Mr Brad Campbell
Bursar
Sydney Grammar School
10-12 College Street
Darlinghurst NSW 2010
21/12/2020

**Weigall Sports Complex, Sydney Grammar School (SSD-10421)
Response to Submissions**

ATTACHMENT 1

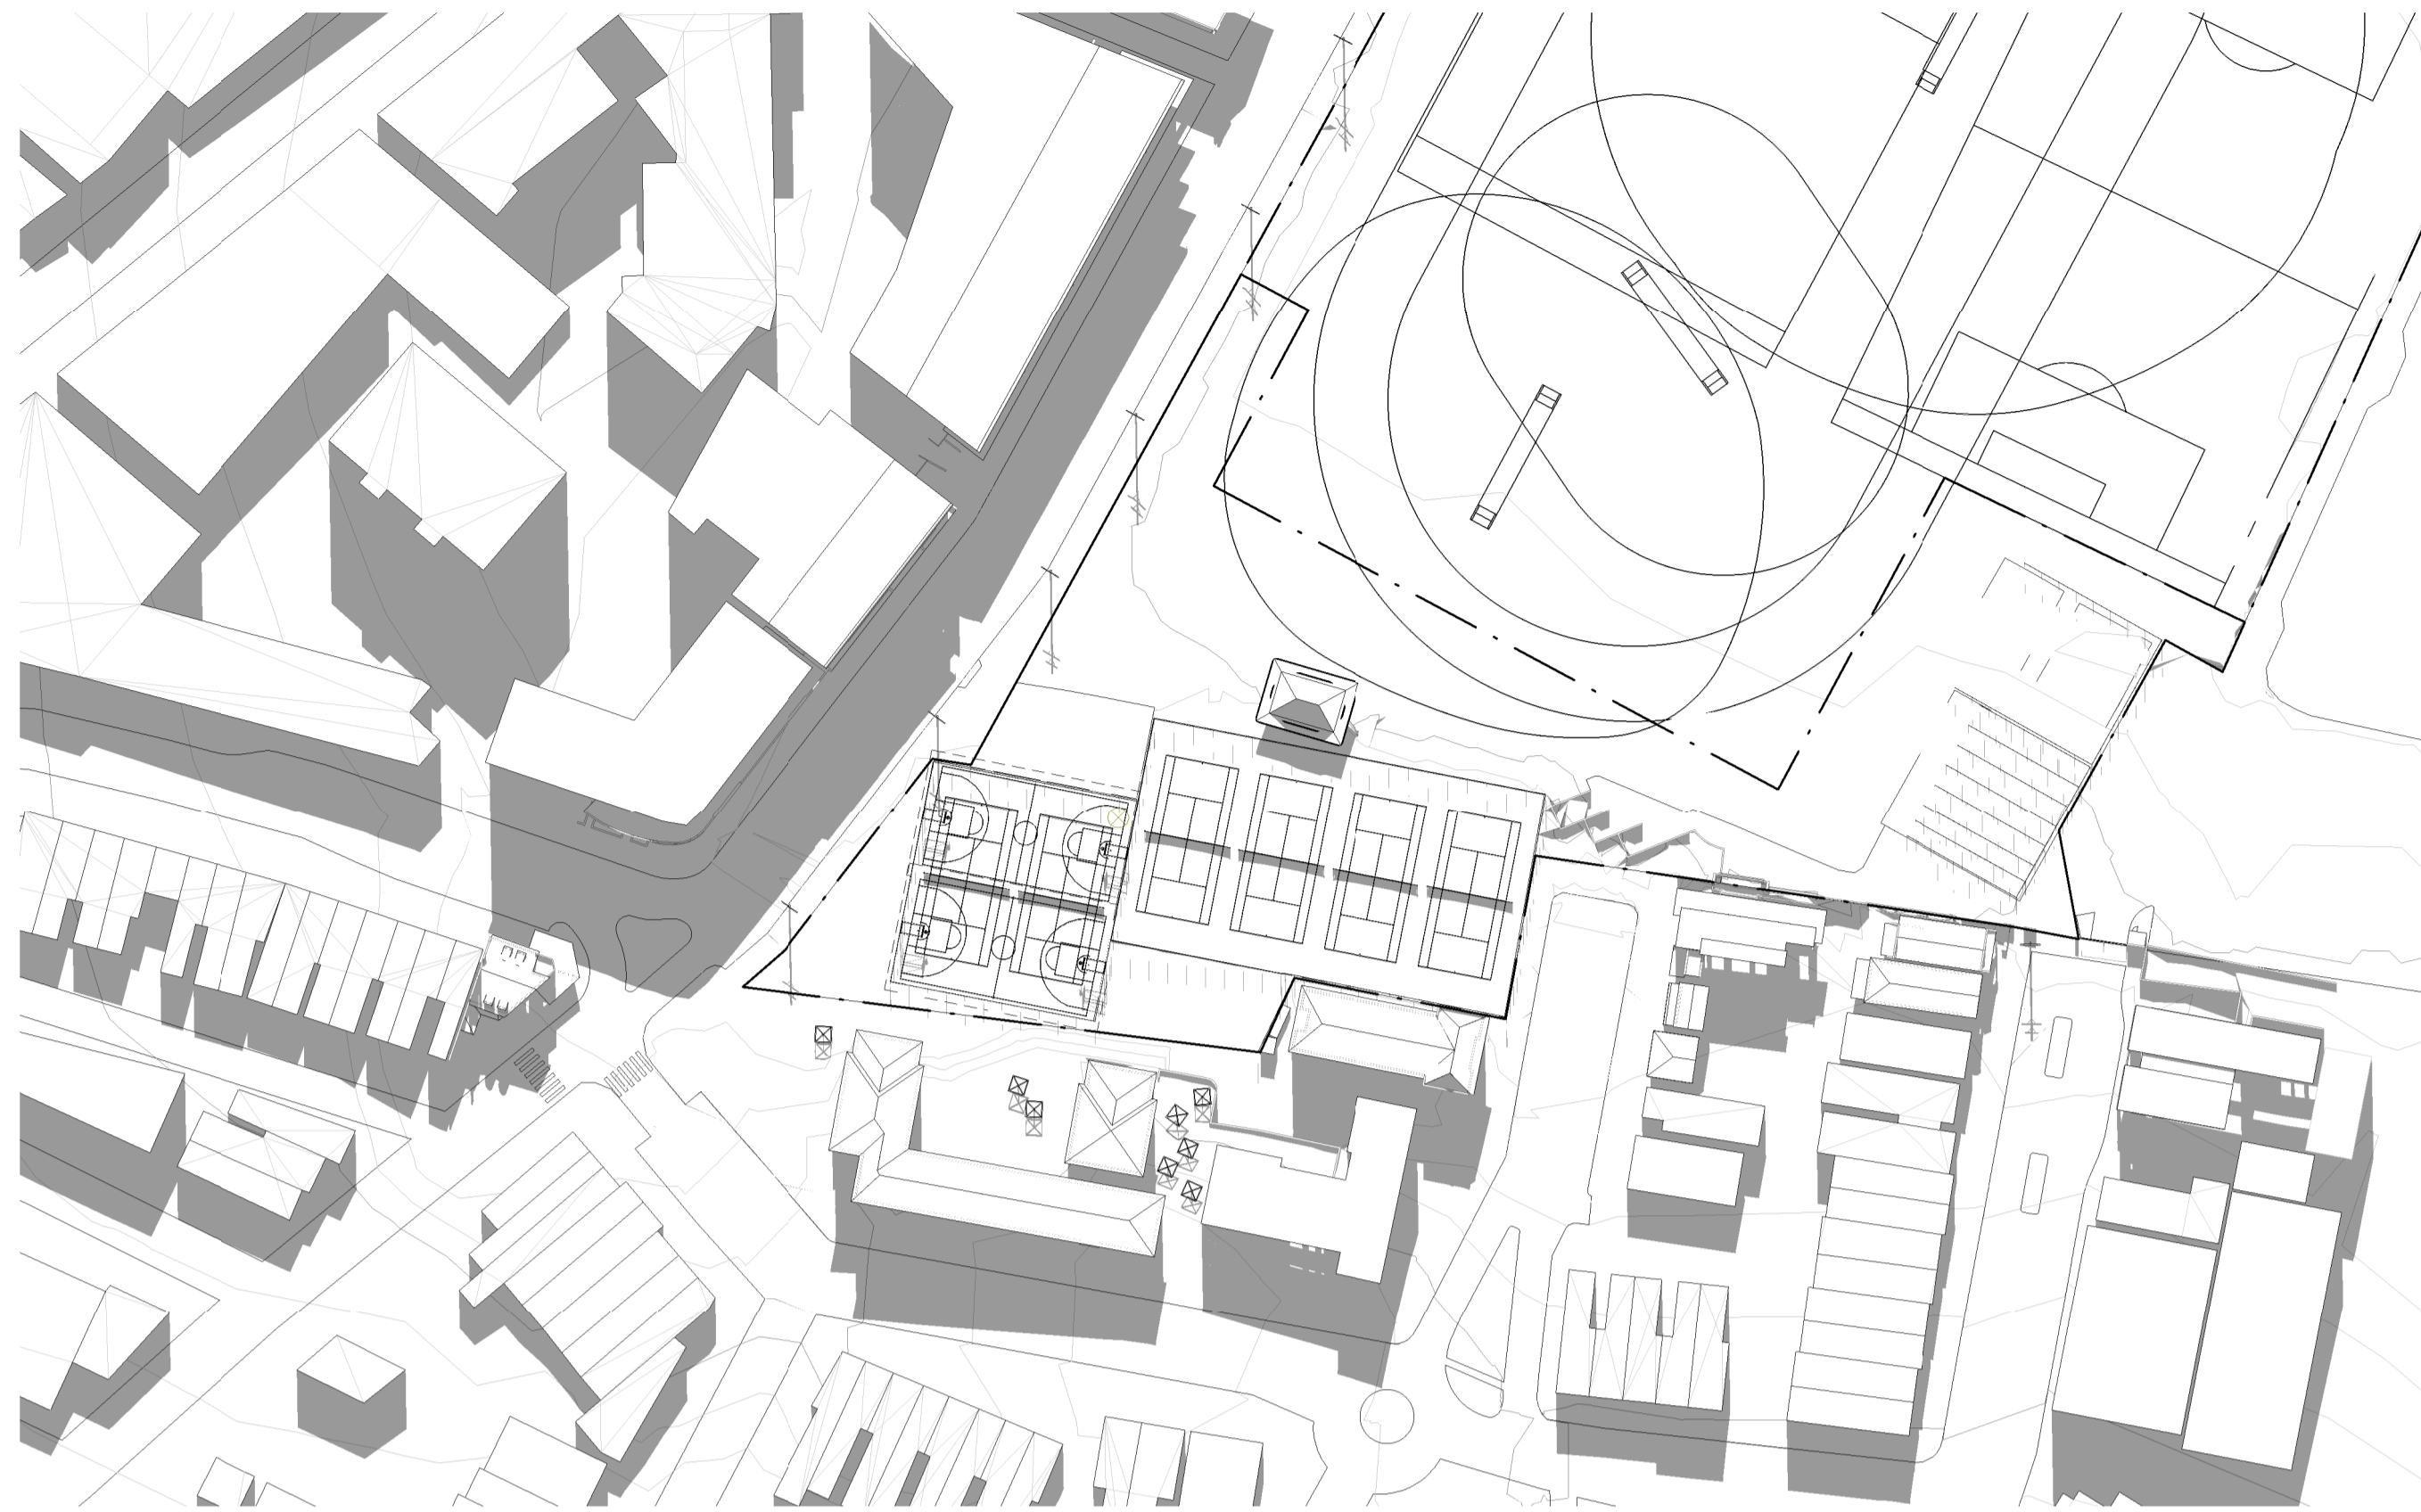
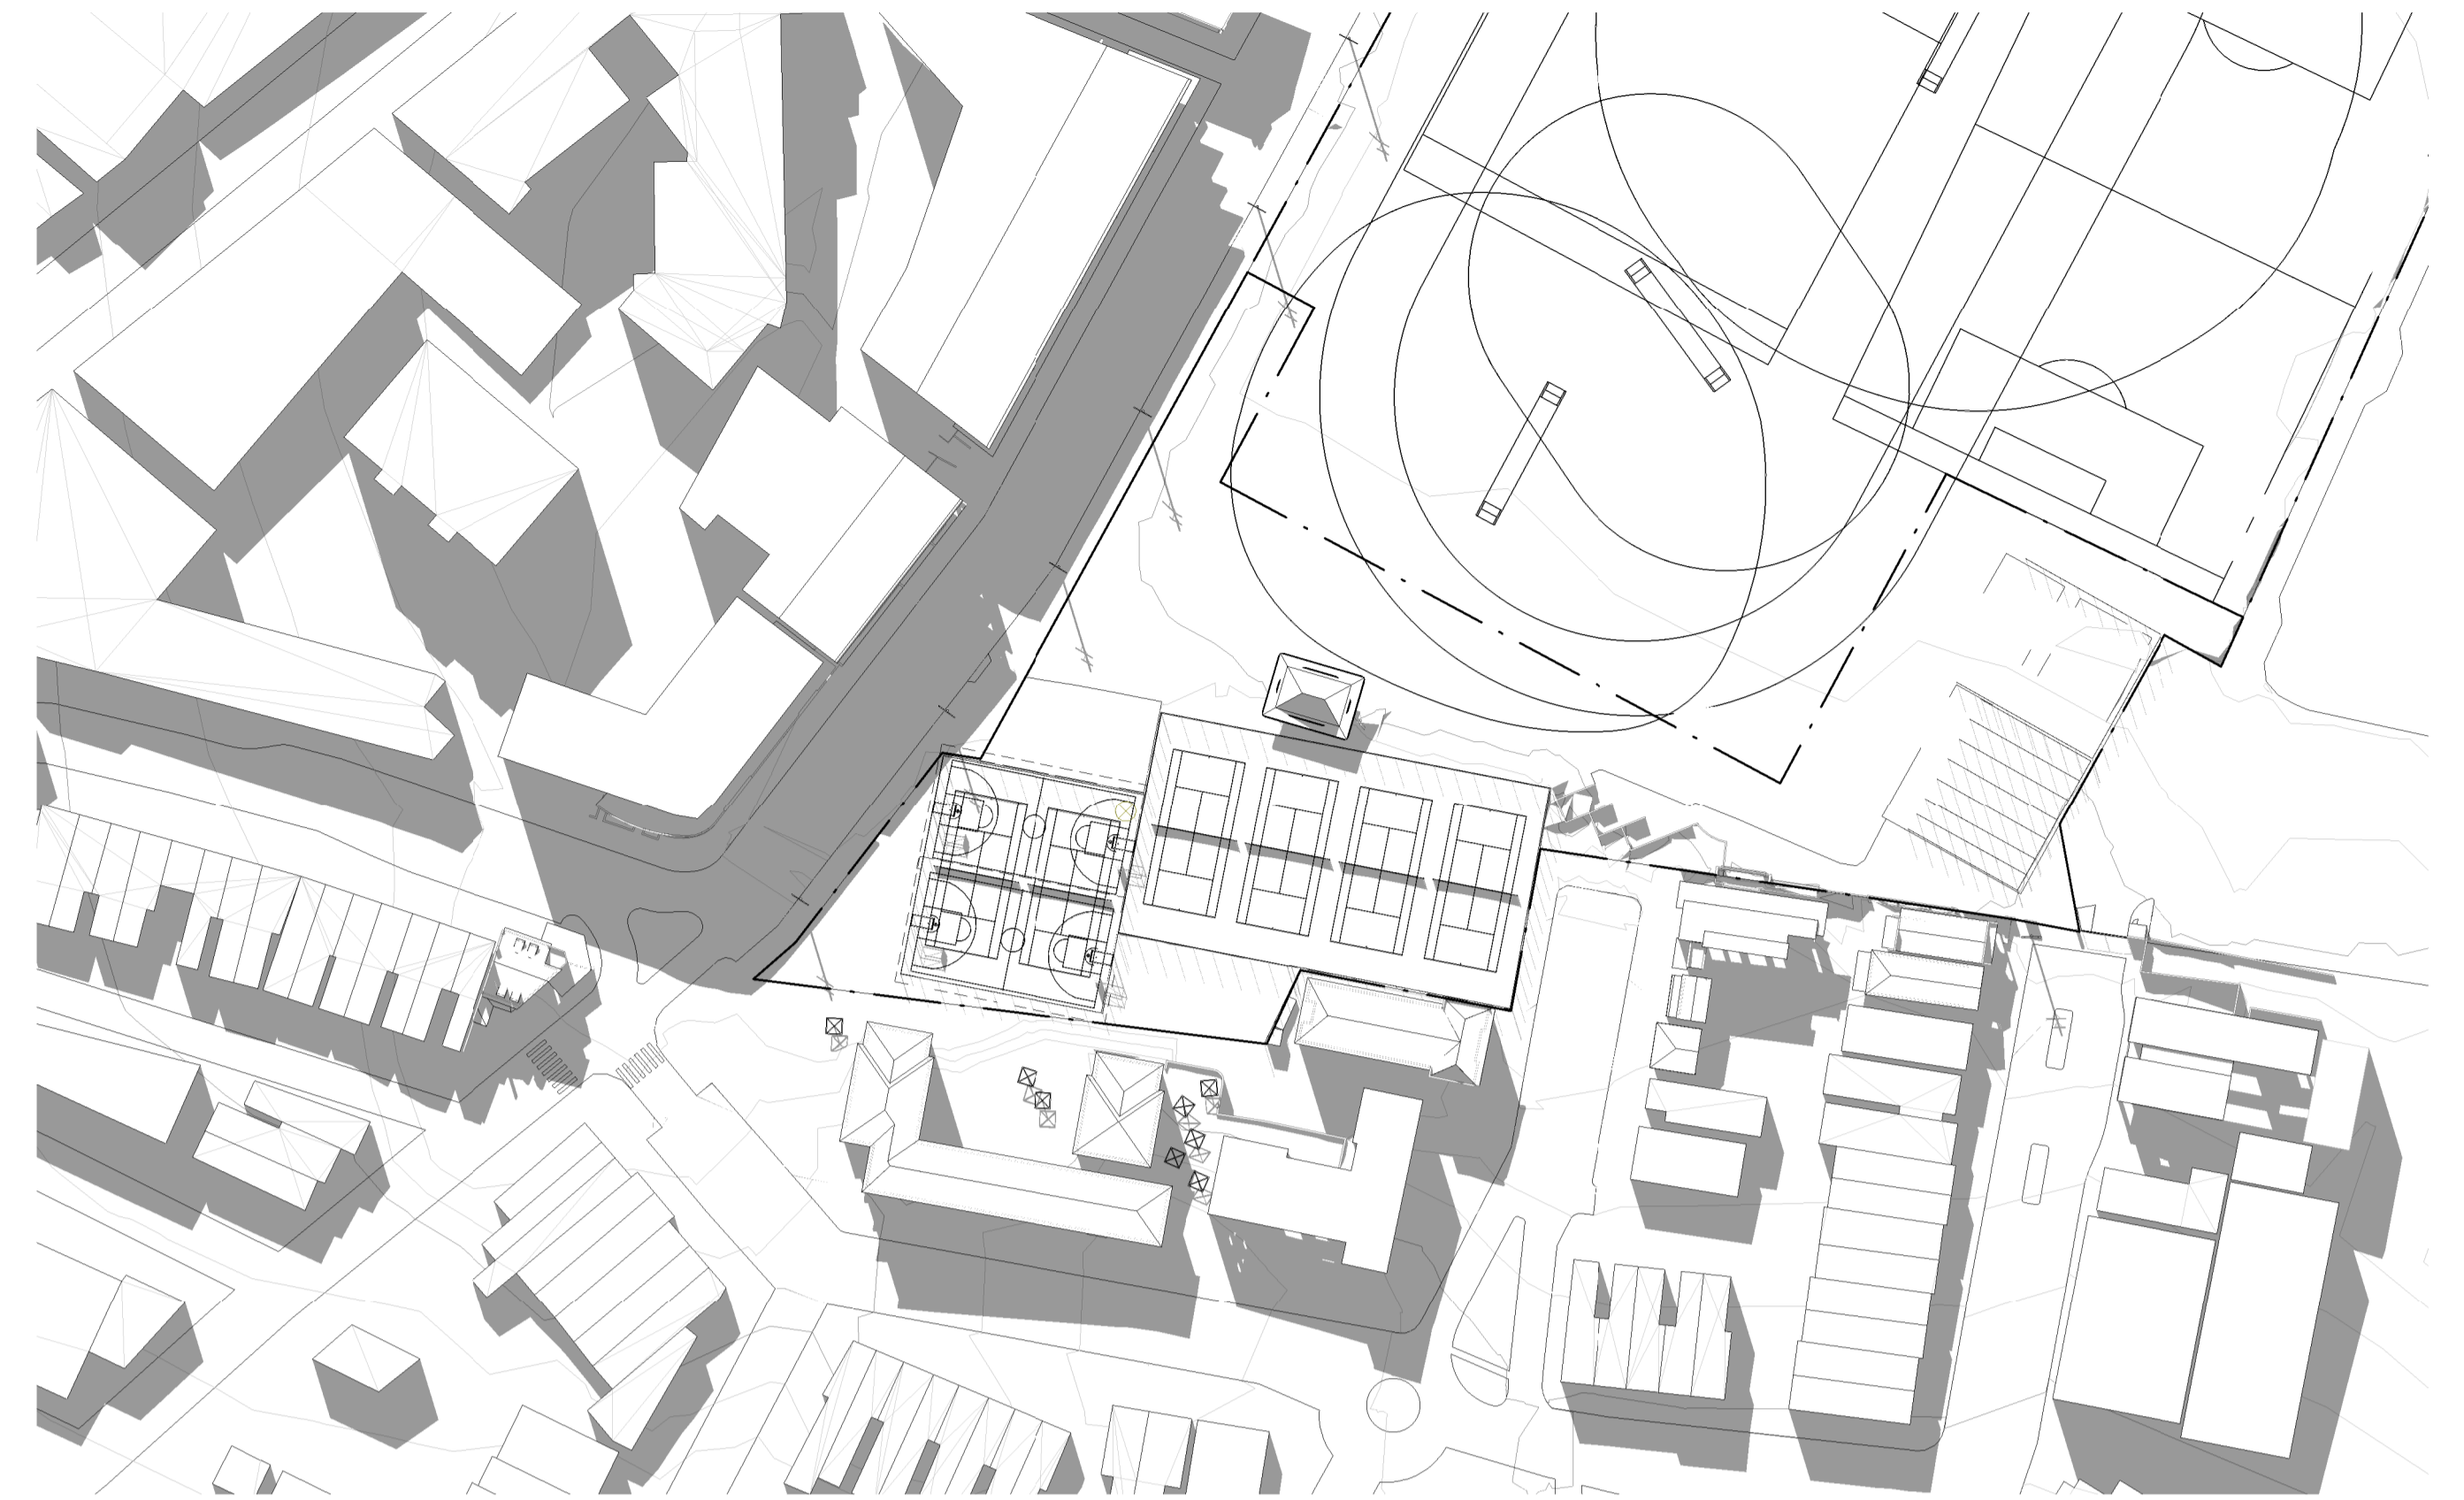
- a) details to demonstrate how the proposed development addresses the visual privacy requirements under ADG with respect to the adjoining RFB to the south. A detailed table of compliance with the separation distances should be included for each of the dwelling units/rooms fronting the proposed development.
- b) hourly shadow diagrams (both elevation and plan view and a schedule with the unit numbers) to demonstrate the total number of hours the dwelling units located along the southern boundary would receive sunlight between 9am – 3pm during winter solstice.
